## THE BRITISH HORSE SOCIETY – BEDFORDSHIRE

### Written Submission for Deadline 1

This submission provides further information on matters raised in RR-1253.

Status
DCO Application

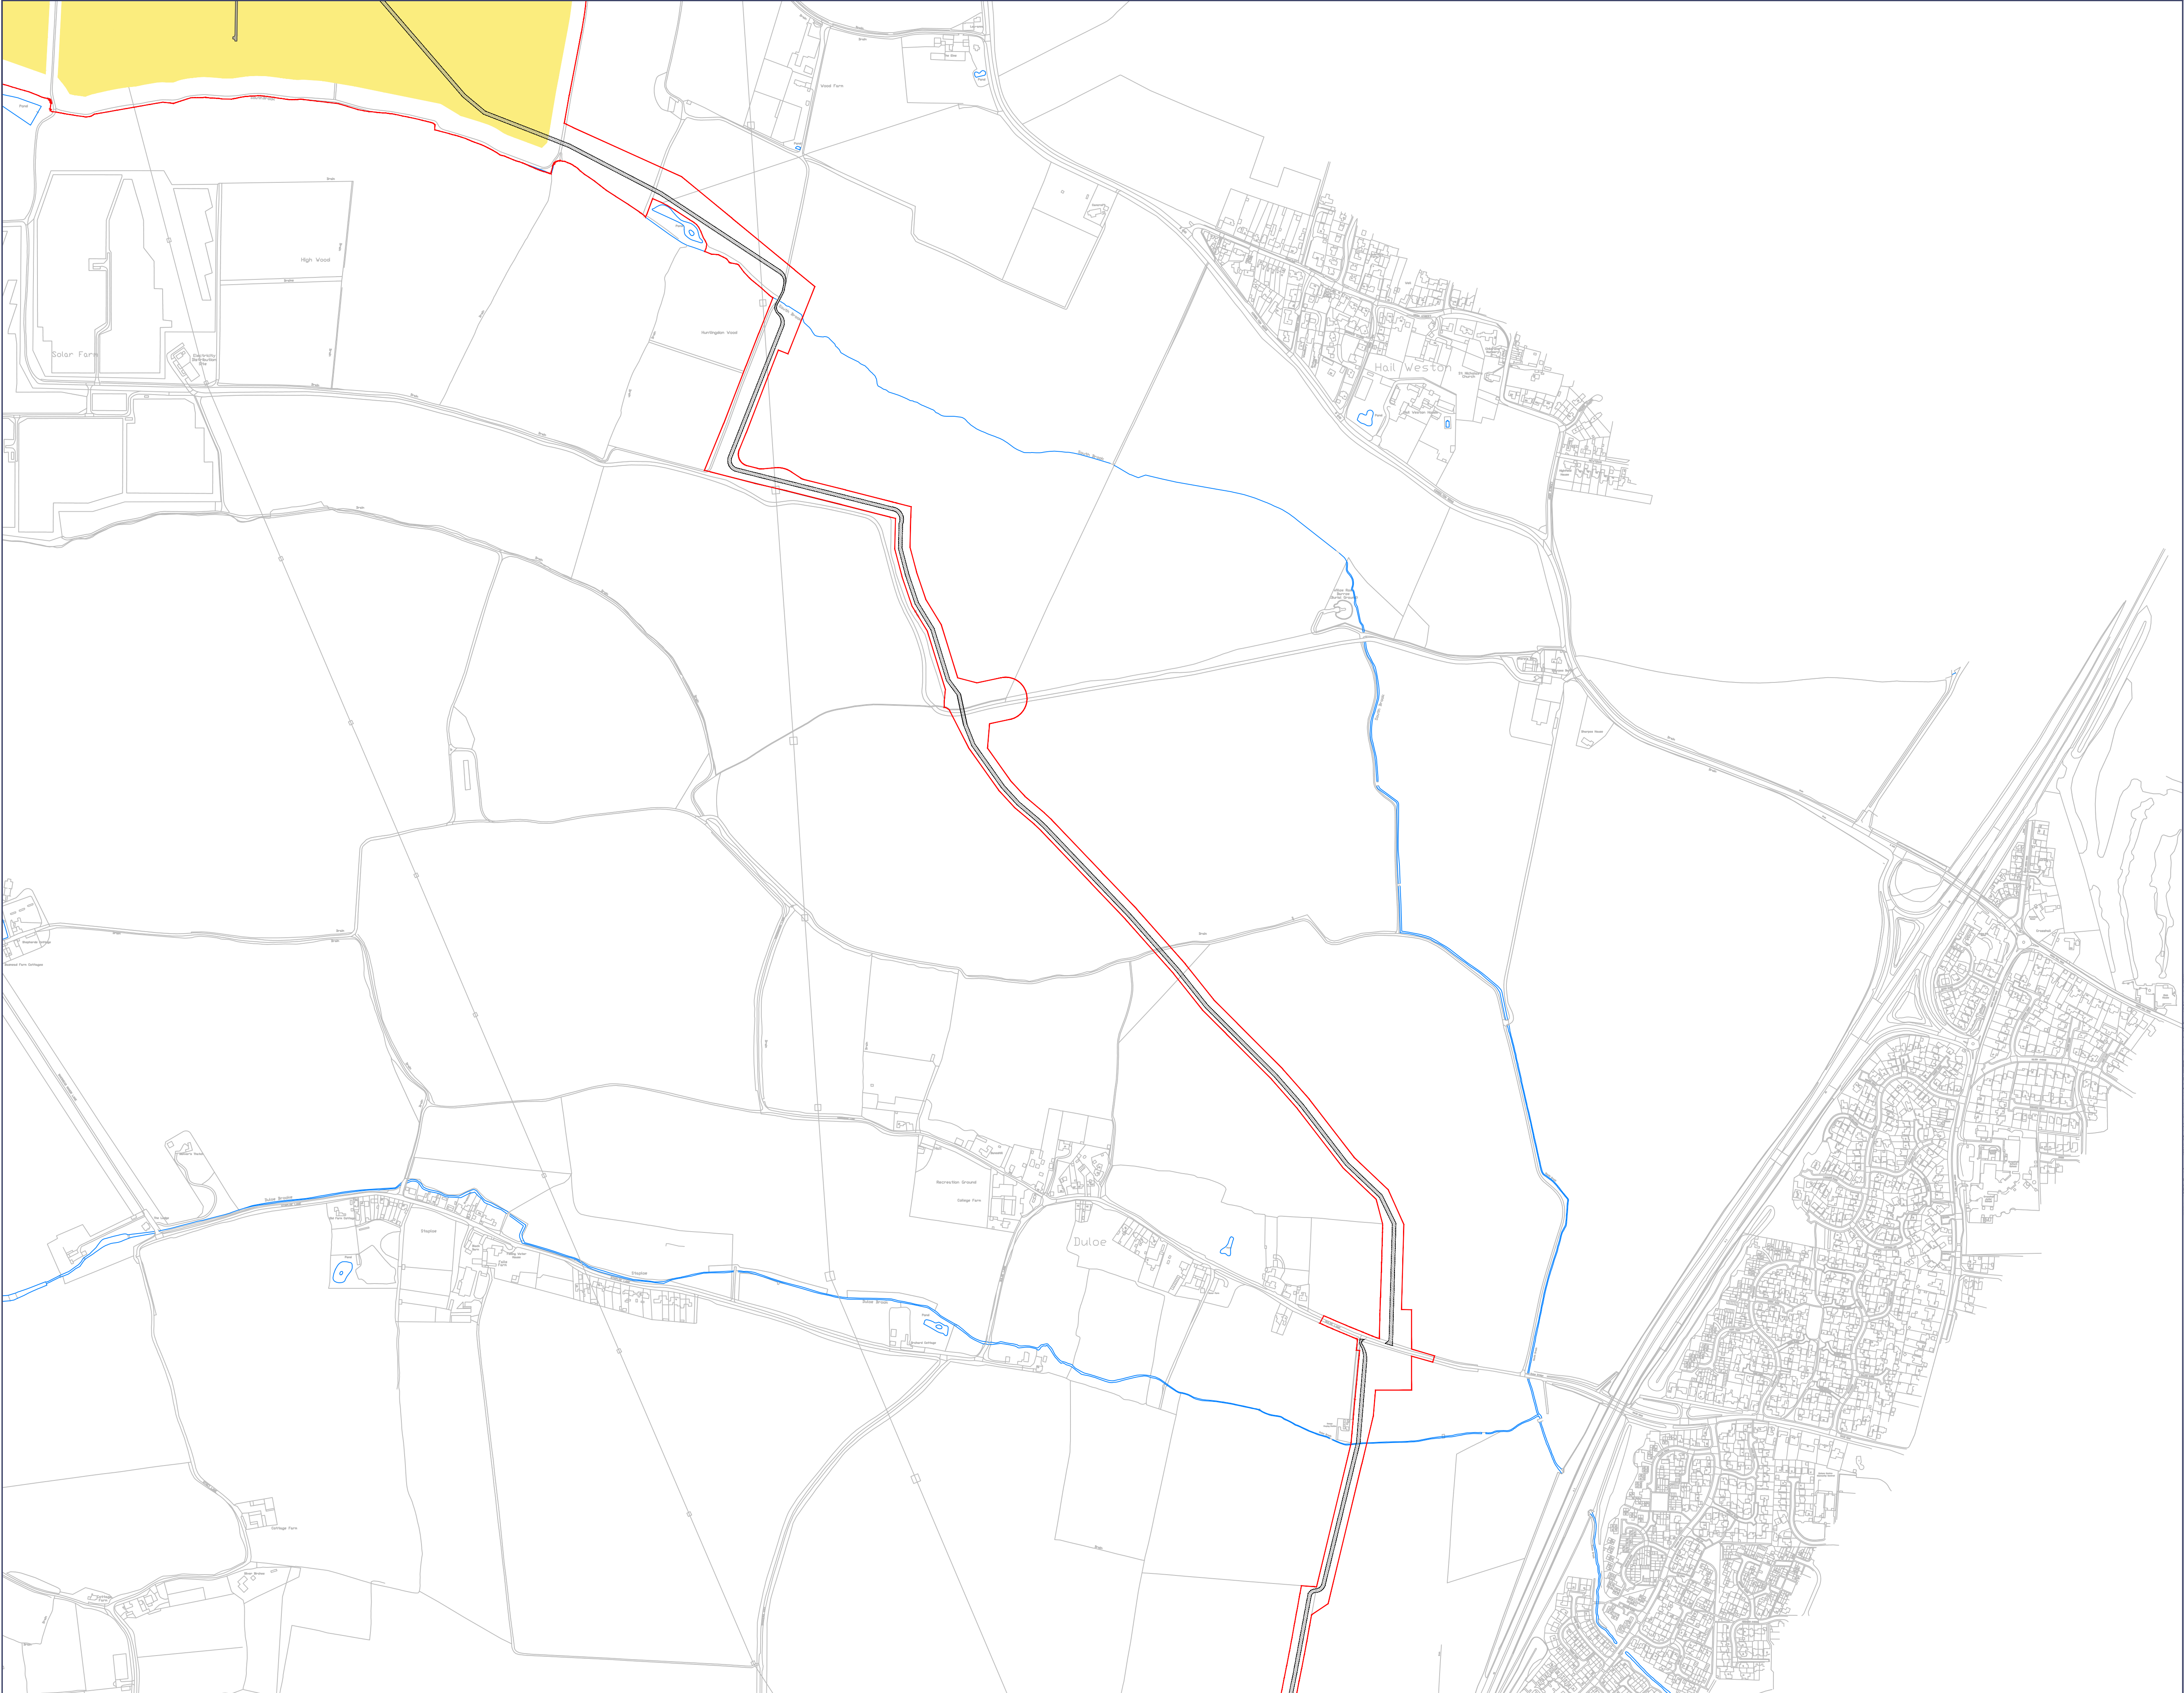
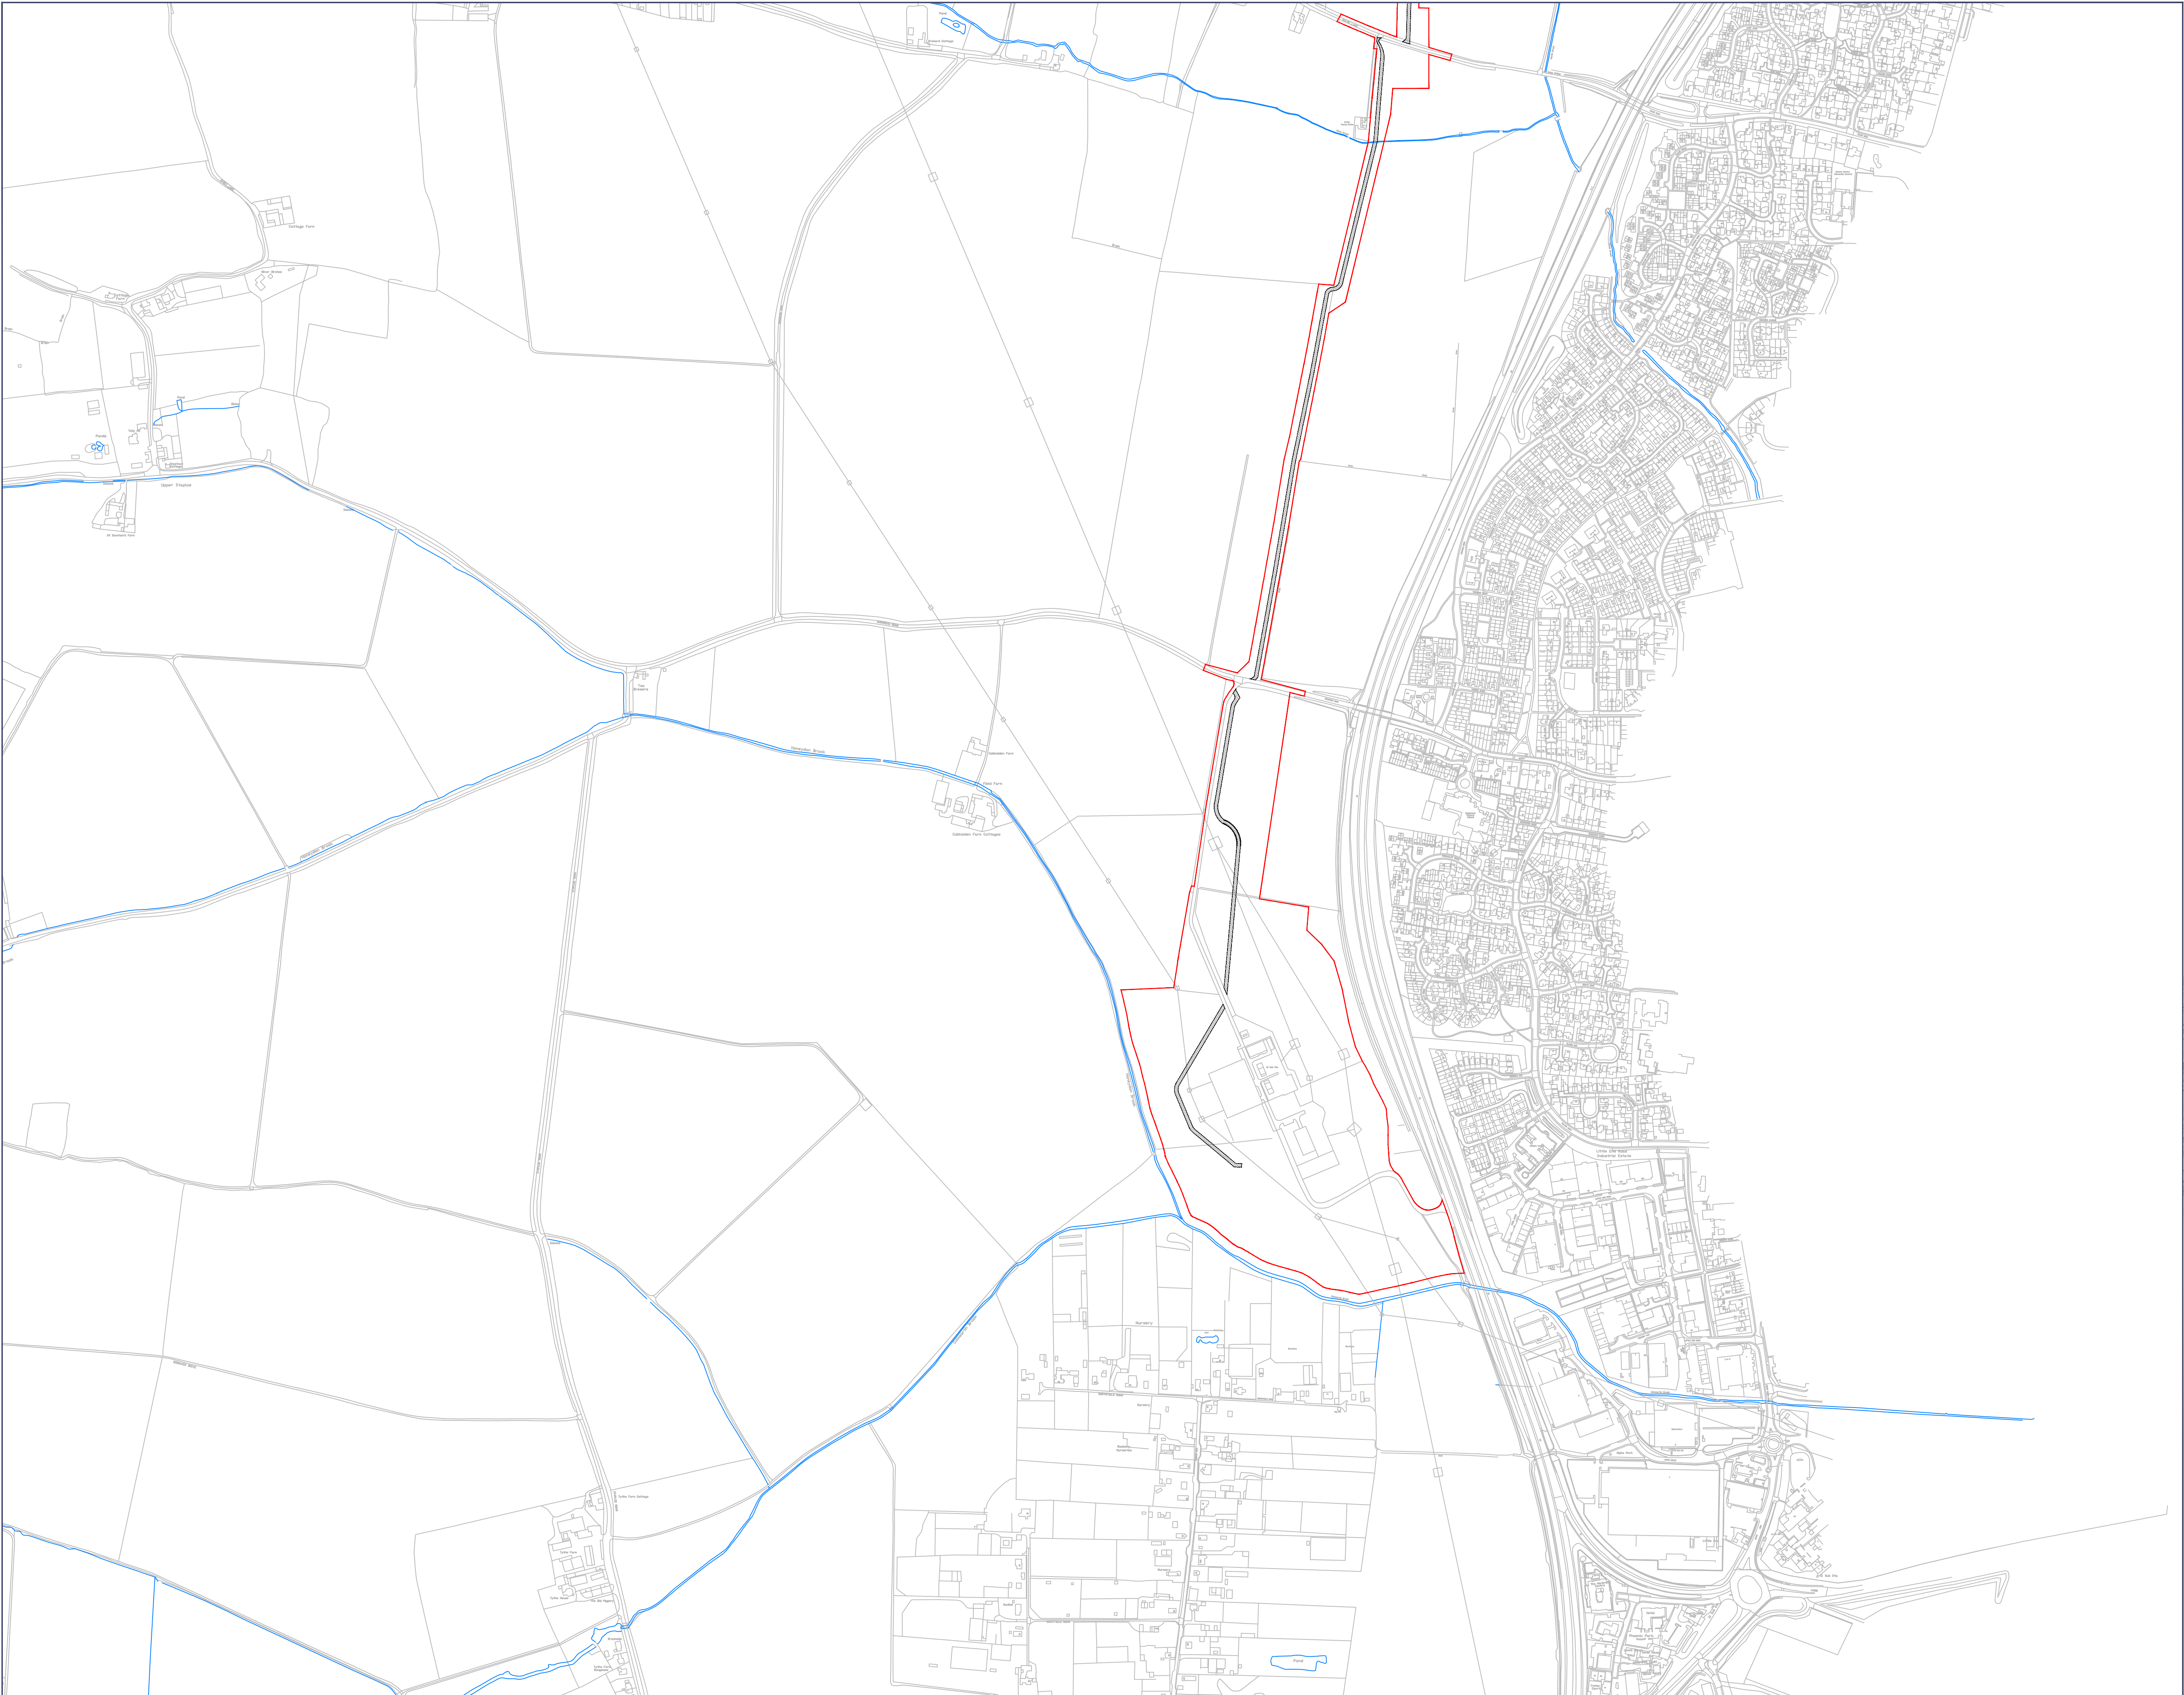
Each of the country roads around Sites A and B is used by equestrians (and also by cyclists). There appears to be no effort made to minimise the use of these roads. There are three sections of road that are planned to be used by construction traffic, each roughly 1km, and in each case there is scope for an alternative safer option available within the development site:

1. All traffic between Sites C and B (so all deliveries etc for both Sites A and B – nearly 2,400 loads or 4,800 trips) will be directed via the narrow Great Staughton Road rather than on an internal access track along the line of or alongside the cable corridor between Site C and B.
2. Access to the southern and northern sections of Site B will use Green End Road – the volume of traffic is not easy to estimate but alternative internal tracks could be provided, requiring only a crossing of Green End.
3. Access to the very northern sections of Site B – those to the north of Great Staughton Road around Kangaroo – will use that road from the junction with Green End Road. Once again, internal routes could be used with just crossings of the road.

APP-125 shows the current proposed routes as black dotted lines in Figures 2-5c and 2-5d.

In summary, these three sections of road do not need to be used for construction traffic access as alternatives could be provided within the site – with just three road crossings required. For regular maintenance vehicles during operation, it would be acceptable for the lower number of smaller vehicles involved to use the local roads. But for any major repowering or replacement during the lifetime of the site and for decommissioning, internal routes should again be used, which might well involve some detailed planning but should be achievable.
